Sea Link

**Document 9.65: Draft Statement of Common Ground Between National Grid Electricity Transmission and the National Trust.**

**Planning Inspectorate Reference: EN020026**

**Version: B  
March 2026**

PLAN VIEW

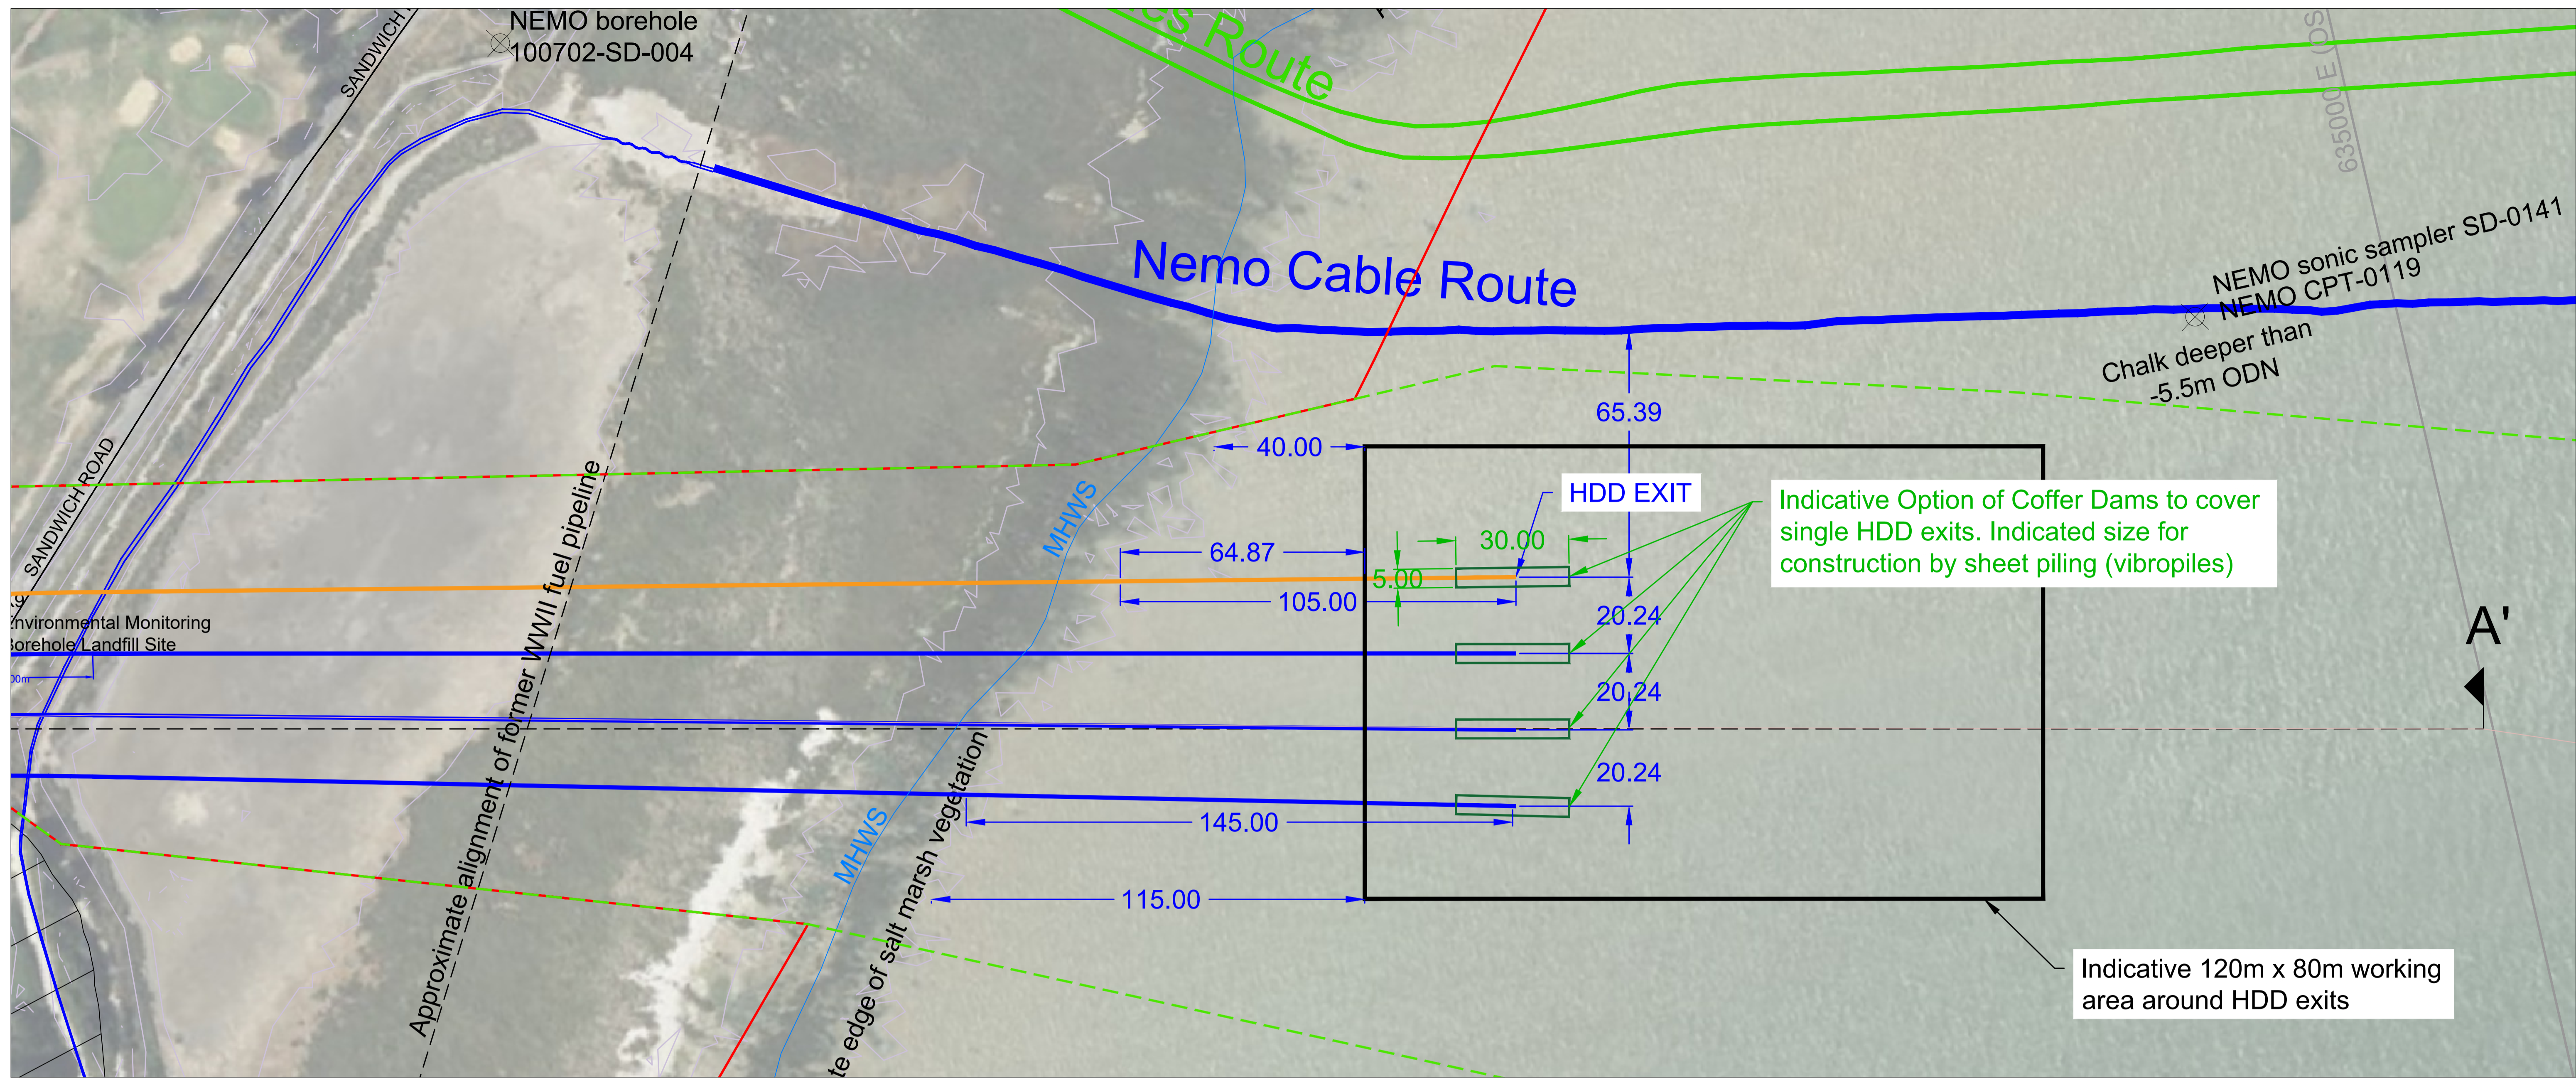
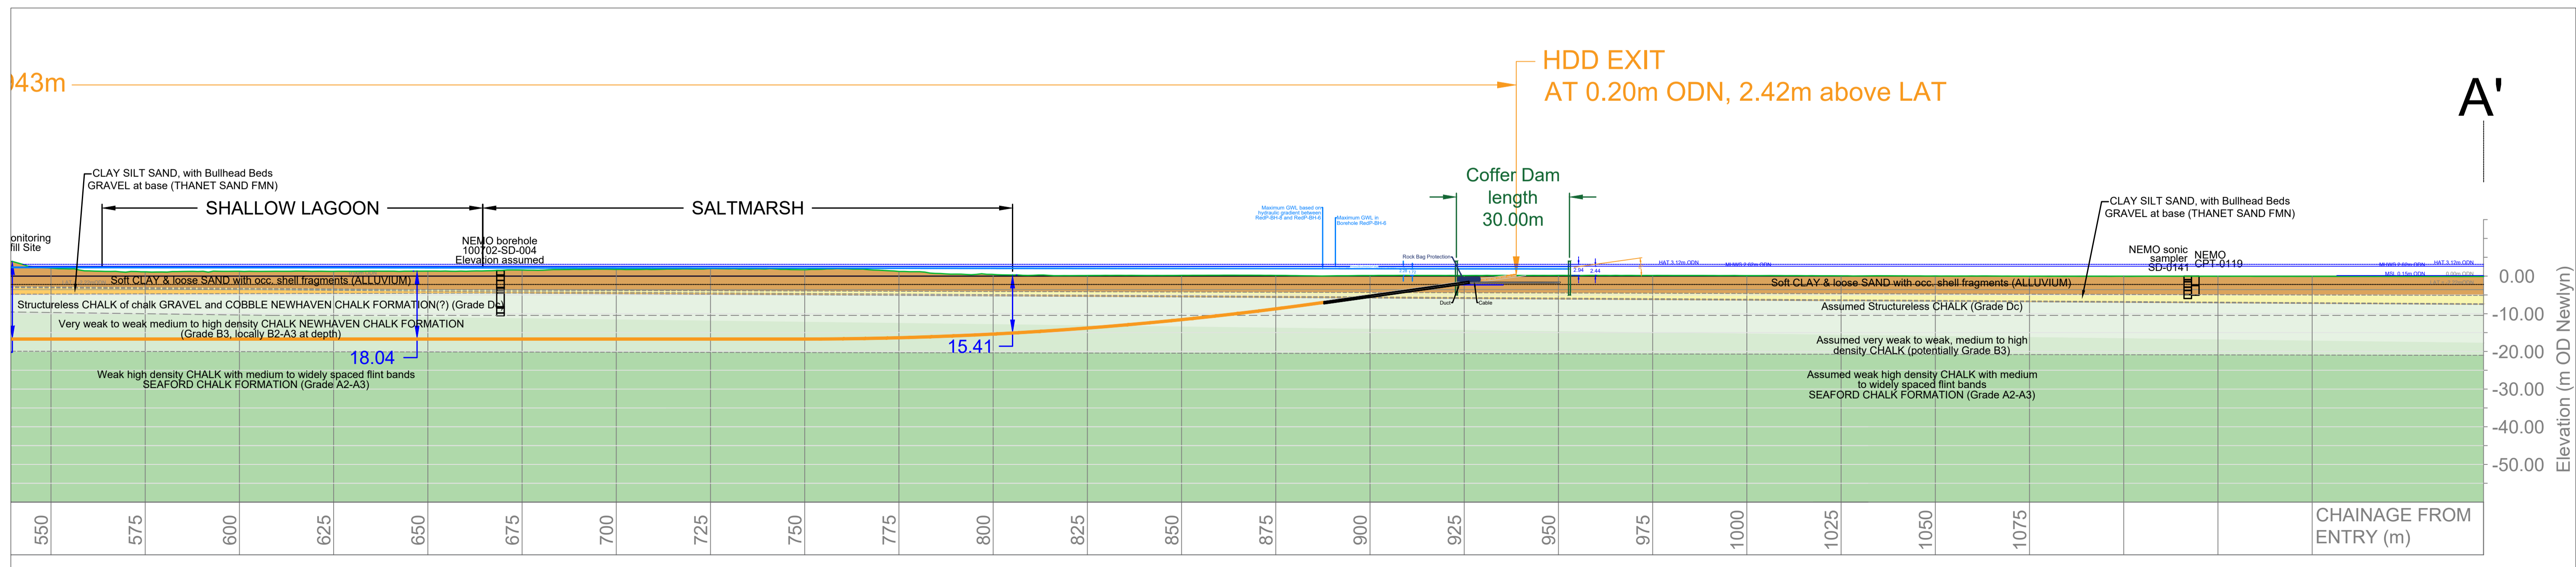
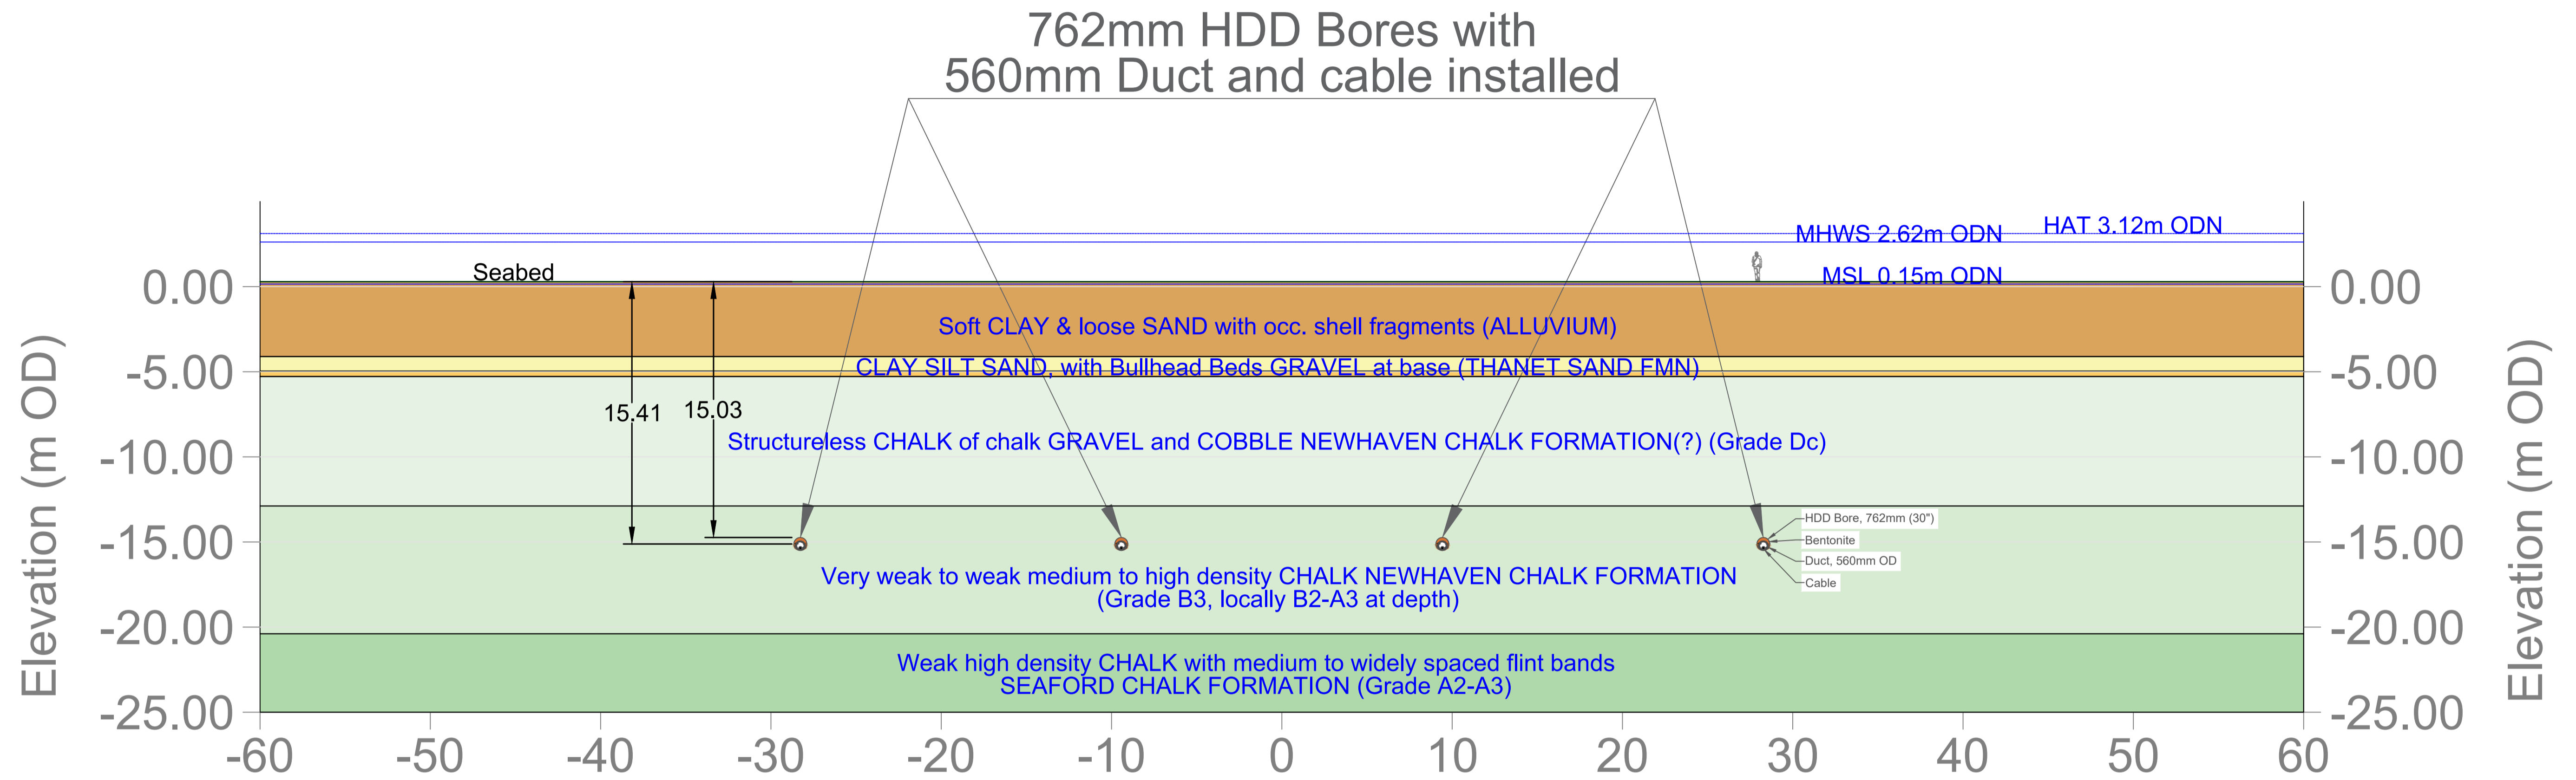
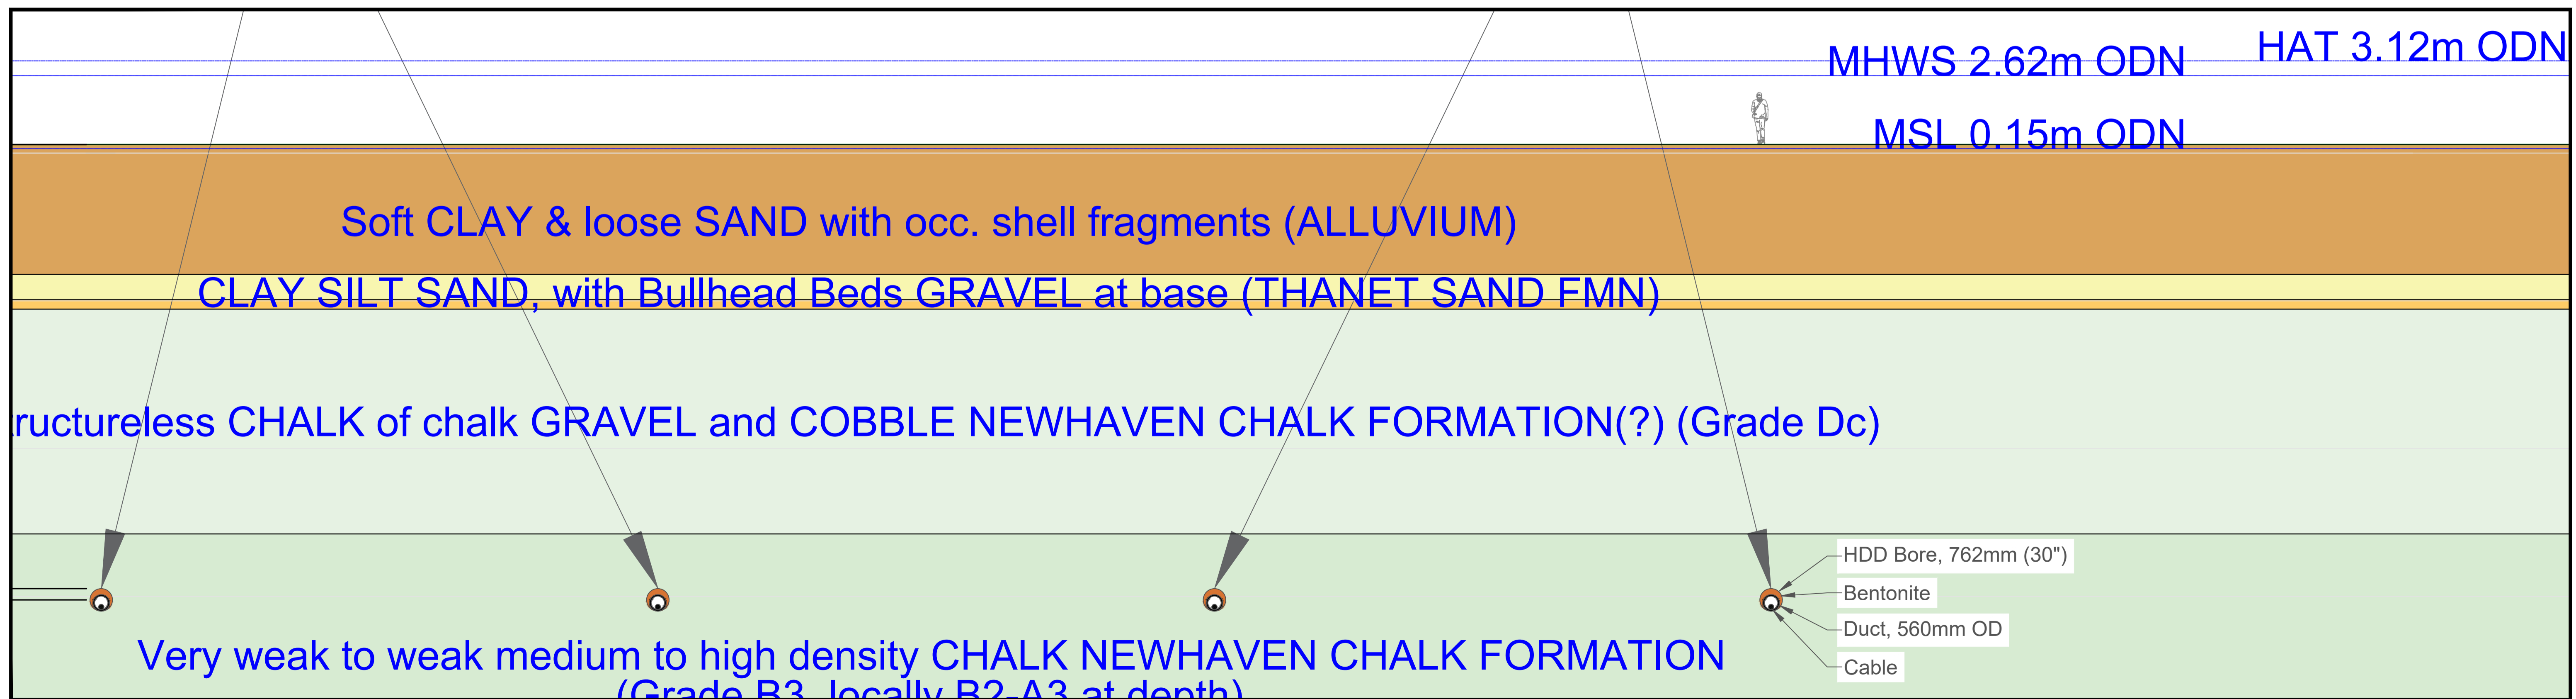
Ref	Relevant Application Documents	Description of Matter	Consultee's Current Position	The Applicant Current Position	Status
Chapter 2	Horizontal Direct Drilling (HDD) Impacts on Ecological designations on National Trust Land	<p>The National Trust does not object to the principle of the proposed offshore high voltage direct current link between Suffolk and Kent with onshore converter stations and connections back to the national electricity transmission system.</p> <p>We would support the developer's use of Horizontal Directional Drilling (HDD) construction methods at Pegwell Bay and would expect to see a firm commitment to undertake this form of engineering if this proves to be less detrimental than other alternatives. The entry point for the HDD is 470m west of the SAC/SPA/SSSI and Trust land. It is proposed to drill at 15-18m depth under the saltmarsh, and the exit point will be to the east of the saltmarsh in intertidal mudflat (Figure 6.4.4.2.4 Habitats present at, and location of, trenchless solution entry/exit points). However, the method statements do not rule out the need for trench installation if HDD proves to be difficult/impossible to use. If trenchless techniques are used, the Trust would have concerns due to the potential of the cumulative impacts on the Nature Reserve arising due to the possibility of the proliferation of cables installed previously for the Nemo link. Consequently, the Trust would want assurances that there will be nothing above ground on our land.</p> <p>The Trust welcomes the Applicant's confirmation. The Trust seeks in addition that the Applicant completes an HDD Management Plan after first consulting with the Trust and other relevant stakeholders.</p>	<p>The current draft DCO prohibits cable installation in Pegwell Bay using techniques that are not trenchless to cross the sensitive saltmarsh. If other than a trenchless technique were proposed at this location, any proposals for alternative methods would require a formal amendment to the DCO and would need to be supported by an additional environmental assessment.</p> <p>However, as outlined in <b>Application Document 7.3 Design Development Report – Appendix A Landfall HDD Feasibility Technical Note [APP-321]</b>, ground investigations have confirmed suitable drilling conditions for HDD. The report states that initial hydrofracture modelling, using ground strength parameters from the ground investigations, shows a 2.8 factor of safety against frac out. This means that the drilling fluid pressure would need to be 2.8 times the pressure required to drill through the formation, to cause a surface frac out in the SSSI. Therefore, there is a very low risk of frac out.</p> <p>The Applicant can confirm that the HDD contractor will produce a detailed, drilling fluid management plan to be approved by the MMO in consultation with relevant stakeholders including Natural England, that includes drilling fluid breakout mitigation measures, where HDD is proposed. This is currently secured within the Deemed Marine Licence through <b>Application Document 9.92 (A) Outline Cable Specification and Installation Plan [REP4-090]</b> submitted at Deadline 4, <b>Application Document 7.5.2 (B) Outline Offshore Construction Environmental Management Plan [REP4-223]</b>, and also within <b>Application Document 9.84 (B) Register of Environmental Actions and Commitments [REP4-234]</b> under <b>B59</b>.</p> <p>In addition to the above, a HDD Landfall Method Statement will be developed following detailed design which is currently secured within the Deemed Marine Licence through <b>Application Document 7.5.2 (A) Outline Offshore Construction Environmental Management Plan [APP-339]</b>. The National Trust will be consulted on this document.</p> <p>A list of relevant securing mechanisms for the Proposed Project is provided in Appendix A. In addition to this, a cross sectional image</p>	Under discussion

Construction methods and mitigation		<p>Given the potential impact this proposal could have on the significant nature designations at Pegwell Bay, the National Trust request more in-depth details on the construction and design methods than would usually be available during the Development Consent Order (DCO) process, so that we can be reassured that the works proposed will provide the highest level of mitigation possible.</p> <p>The National Trust would encourage the developer to consider additional mitigation in the form of funding to support the ongoing management and future conservation of important coastal and marine species and habitats in the Pegwell Bay and Sandwich Bay SAC area and would welcome further discussion on this topic during the DCO process with the National Trust as landowner, the Kent Wildlife Trust as site manager and other key stakeholders.</p> <p>The Trust considers there remains significant areas of uncertainty around the details of construction and potential ecological impacts. The includes, but is not limited to the impact of x4 ducts running through the SSSI intertidal habitat (requiring a 80m and not 30m wide easement) which the applicant has recently advised the Trust within the last week.</p> <p>It is not clear to the Trust how the applicant has applied the mitigation hierarchy in relation to impacts on the Sandwich Bay to Hacklinge Marshes SSSI.</p> <p>The location of the exit points are not clear. It would be clear if these are shown on a location plan with the pits dimensionally referenced (horizontally and vertically) to the MHWS and MLWS. Its also not clear if the exit pits will comprise a permanent buried construction of if they are simply locations within the cofferdams at the HDD/duct installation and subsequently the cable installation. The detailed specifications for the HDD</p>	<p>Further project description information in regard to Pegwell Bay construction activities is available in <b>Application Document 9.13 (C) Pegwell Bay Construction Method Technical Note [REP4-229]</b></p> <p>As presented in <b>Application Document 6.2.4.1 (E) Part 4 Marine Chapter 1 Physical Environment [REP4-027]</b>, at Pegwell Bay, the magnitude of the impact on nearshore physical processes morphology due to the excavation of the HDD pits and wider cable installation is small as works will be temporary, relatively localised and any changes to the in the intertidal zone seafloor morphology will naturally recover via sediment transport processes driven by wave and current action in shallow waters.</p> <p>There will, therefore, be no significant effects to intertidal or shallow subtidal ecology or morphology. As no significant effects are concluded, no further additional mitigation than currently outlined in <b>Document 7.5.3.2 (B) CEMP Appendix B Register of Environmental Actions and Commitments (REAC) [CR1-043]</b> is proposed.</p> <p>A meeting was held on MS Teams between National Grid and the National Trust to discuss <b>Application Document 9.13 (C) Pegwell Bay Construction Method Technical Note [REP4-229]</b> on 11/02/2026.</p> <p>The Applicant has provided a more detailed image of the intertidal exit pits including MHWS and MLWS in Appendix B. Additionally, a vertical cross section of the HDD profile at Pegwell Bay is also included within Appendix B.</p> <p>The exit pits during HDD construction are temporary excavations within the planned cofferdams to finalise the below ground termination of the ducts. They also include the installation of temporary protection, such as rock bags or concrete mattresses, to ensure the duct ends are secure while awaiting cable installation. The excavated material from the pits will be used to fill the pits on completion of these temporary works.</p>	Under discussion

Ref	Relevant Application Documents	Description of Matter	Consultee's Current Position	The Applicant Current Position	Status
			<p>drilling fluid and the duct infill after the cables have been installed needs to be known in order to form an opinion about their environmental credentials in the circumstances of loss of the marine environment. Until the actual construction details and method statements for the cable installation and burial are defined it is difficult to form an opinion on potential environmental impact and appropriate mitigations in both the construction stages and the longer-term operational stage. We would concur with Natural England in the need for a HDD Management Plan, Intertidal Management Plan and Intertidal HRA to ensure that any potential issues arising during construction can be remedied without harm to the marine environment. A suggested solution the above would be for Trust to agree with the Applicant that the Trust will receive in a timely manner, the detailed designs, relevant material specifications and construction method statements and the Applicant to have regard to the Trust's comments.</p>	<p>For cable installation works, the duct ends will again be exposed by temporary excavations to enable cable installation. Upon completion of cable installation, permanent protection, such as rock bags, will be placed on the duct ends. The top of the protection will be a sufficient depth below seabed level to ensure it remains buried, and excavated material from the pits will again be re-used to fill the pits to natural seabed level. An indicative arrangement of the duct, protection, and cable at the HDD exit is shown in Appendix B.</p> <p>Following installation of the cable, the duct is expected to be filled with fresh water, and the duct ends sealed to prevent egress or ingress of external seawater or groundwater.</p> <p>With regards to drilling fluid specifications, the Applicant confirms that the draft Deemed Marine Licence currently states:</p> <p><i>“(1) Unless otherwise agreed in writing by the MMO, all chemicals used in the construction of the authorised development must be selected from the List of Notified Chemicals approved for use by the offshore oil and gas industry under the Offshore Chemicals Regulations 2002 (as amended) as maintained by Cefas”.</i></p> <p>The Applicant confirms that the HDD contractor will produce a detailed, drilling fluid management plan to be approved by the MMO in consultation with relevant stakeholders including Natural England and the National Trust, that includes drilling fluid breakout mitigation measures, where HDD is proposed. This is currently secured within the Deemed Marine Licence <b>Application Document 9.92 (A) Outline Cable Specification and Installation Plan [REP4-090]</b>, and also within <b>Application Document 9.84 (B) Register of Environmental Commitments (REAC) [REP4-234]</b> under <b>B59</b>.</p> <p>A Habitat Regulations Assessment (HRA) (<b>Application Document 6.6 (F) Habitats Regulations Assessment Report [REP4-057]</b>) has been completed and submitted for the whole project, including the intertidal designations at Pegwell Bay. A separate Intertidal HRA is therefore not required.</p> <p>The Applicant confirms that it has updated commitment <b>B59</b> within the Register of Environmental Actions and Commitments to include the provision for the National Trust to be consulted on the Landfall Method Statement prior to commencement of HDD activities (<b>Application Document 9.84 (B) Register of Environmental Commitments (REAC) [REP4-234]</b>).</p> <p>The Applicant also confirms that all activities at the Landfall are captured within <b>Application Document 7.5.2 (B) Outline Offshore Construction Environmental Management Plan [REP4-223]</b> already submitted as part of the Application. A separate Intertidal Management Plan is therefore not required at</p>
